CARRIGALINE, CO. CORK
Landscape Design Rationale Report

PROJECT NO. 21623
April 2022

The Inspector's Report on Recommended Opinion: 311799-21 and Notice of Pre-Application Consultation Opinion: Case Reference: ABP-311799-21 required additional items to be given further consideration. Below are CSR responses to landscape items raised:

Cork County Council's Consultation Opinion: Case Reference: ABP-311799-21 / Cork County Council (CCC) Ref. No. 35 Carrigaline. Below are CSR responses to landscape items raised:

Drawing file: 313720 / 66. Riverside Pedestrian Link to Main Street.pdf

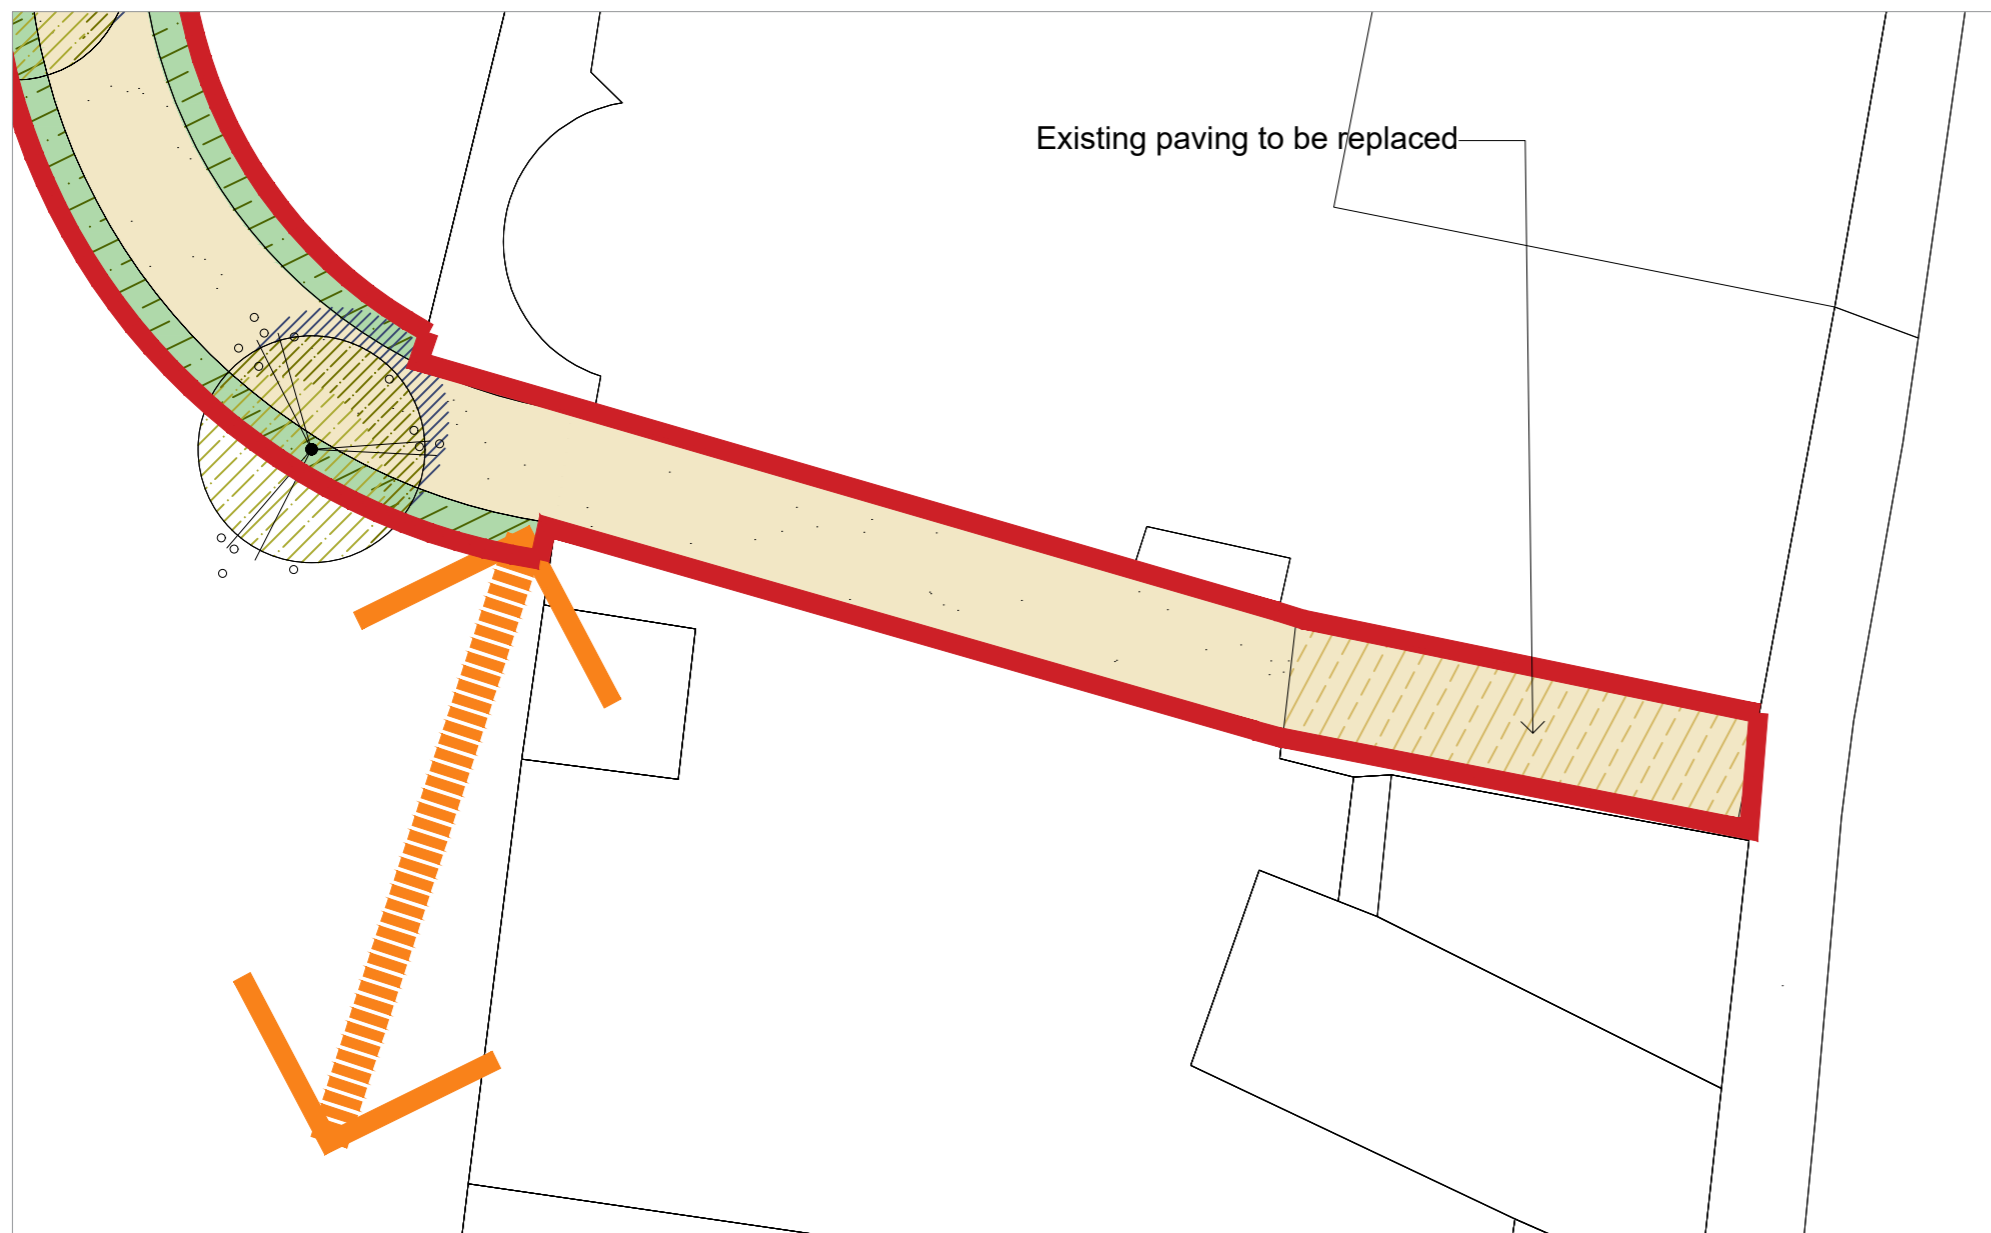
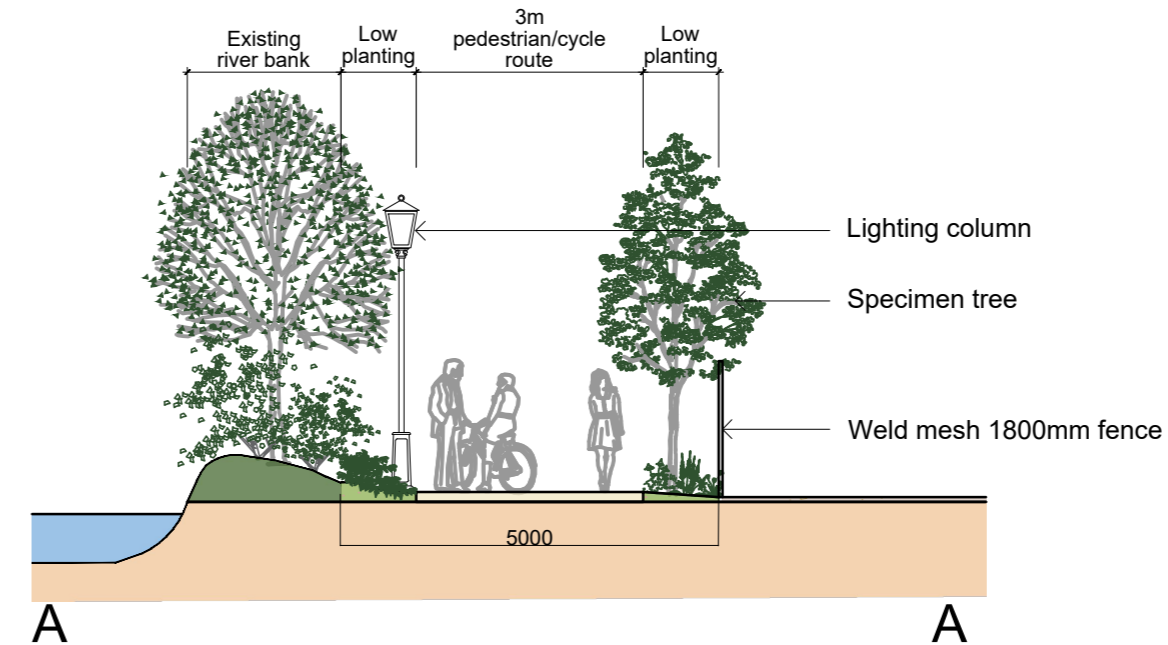
- **CCC Opinion:** *Design details of proposed pedestrian route across third party lands to the east connecting with the town core*

- **CCC Opinion:** *Details of riverside seating, viewing, meeting areas, etc. and how the route traverses the Co-Op yard and how it ultimately connects in with the main street. Is route aspirational or deliverable?*

Response: Refer to Riverside Link to Town Centre drg. no. 21623-2-103 which shows the proposed route and includes a representative section and precedent imagery to demonstrate proposed materials, planting, lighting and fencing.

- **Response:** Details of riverside seating, viewing, meeting areas, etc. are shown on Landscape Masterplan drg. no. 21623-2-1 and Sections drg. no. 21623-2-102. The area also includes a coffee kiosk with tables and chairs overlooking the adjacent play area and outdoor gym in the park. Refer to Riverside Link to Town Centre drg. no. 21623-2-103 for the proposed route and includes a representative section and precedent imagery to demonstrate proposed materials, planting, lighting and fencing. The route is deliverable as per the letter of agreement from the owner of the adjoining property.
